Grove Comments

Revised site Plan July 7, 2006

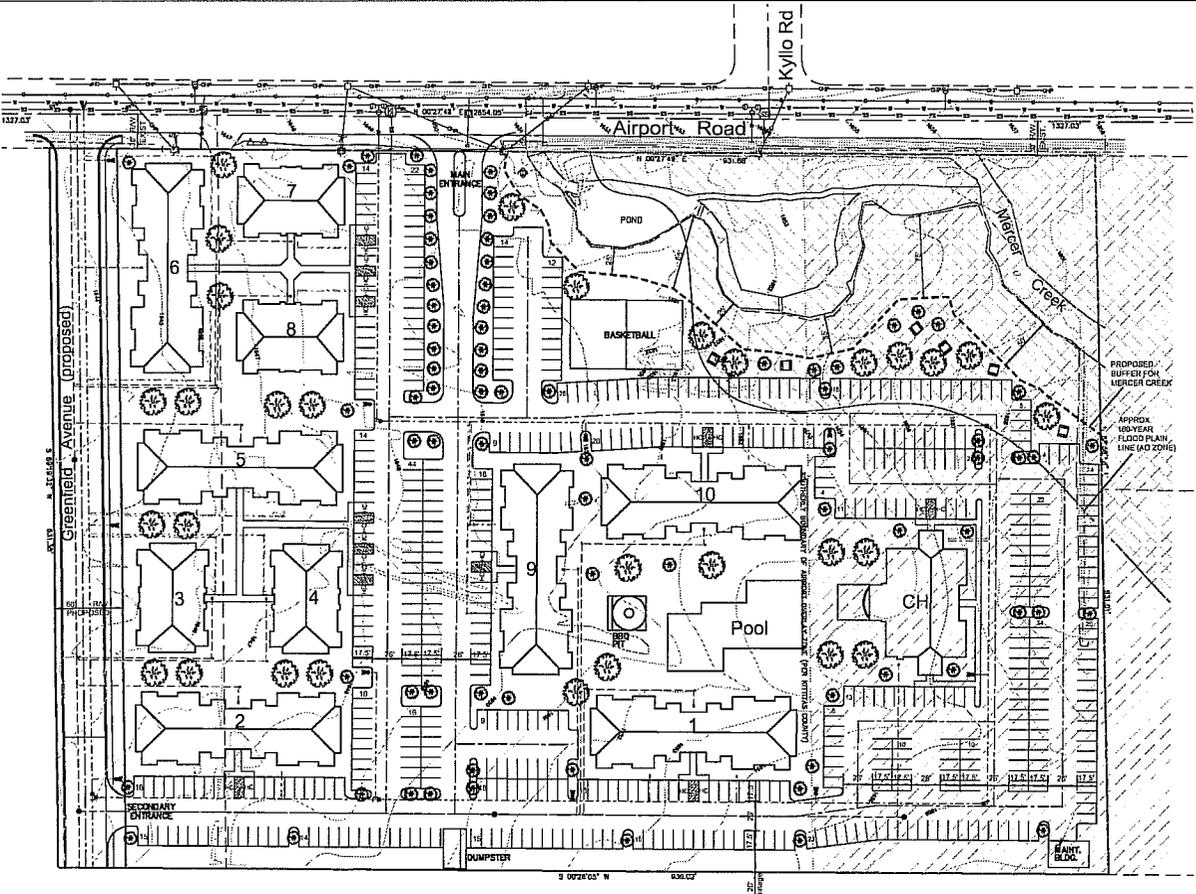
Brenda Larsen (Code Enforcement)- **Fire apparatus access roads shall be a minimum of 26 feet, aside from parking areas. There may be no more than 250' spacing between fire hydrants, "no parking: fire lane" signs must be posted in front of the proposed volleyball and basketball courts, in addition to the main and secondary entrances. The signs must comply with IFC Appendix D. The southeast corner of the proposed development does not meet the minimum requirements for fire apparatus access. Additional fire hydrants are necessary of the south and southwest side of the complex.**

Ellensburg Fire Department, Rich Elliot- No issues/concerns with the project in terms of service delivery by the fire dept. Likely require **installation of fire sprinklers and an alarm system. Additionally the fire dept. will need to review the access and fire hydrant placement.**
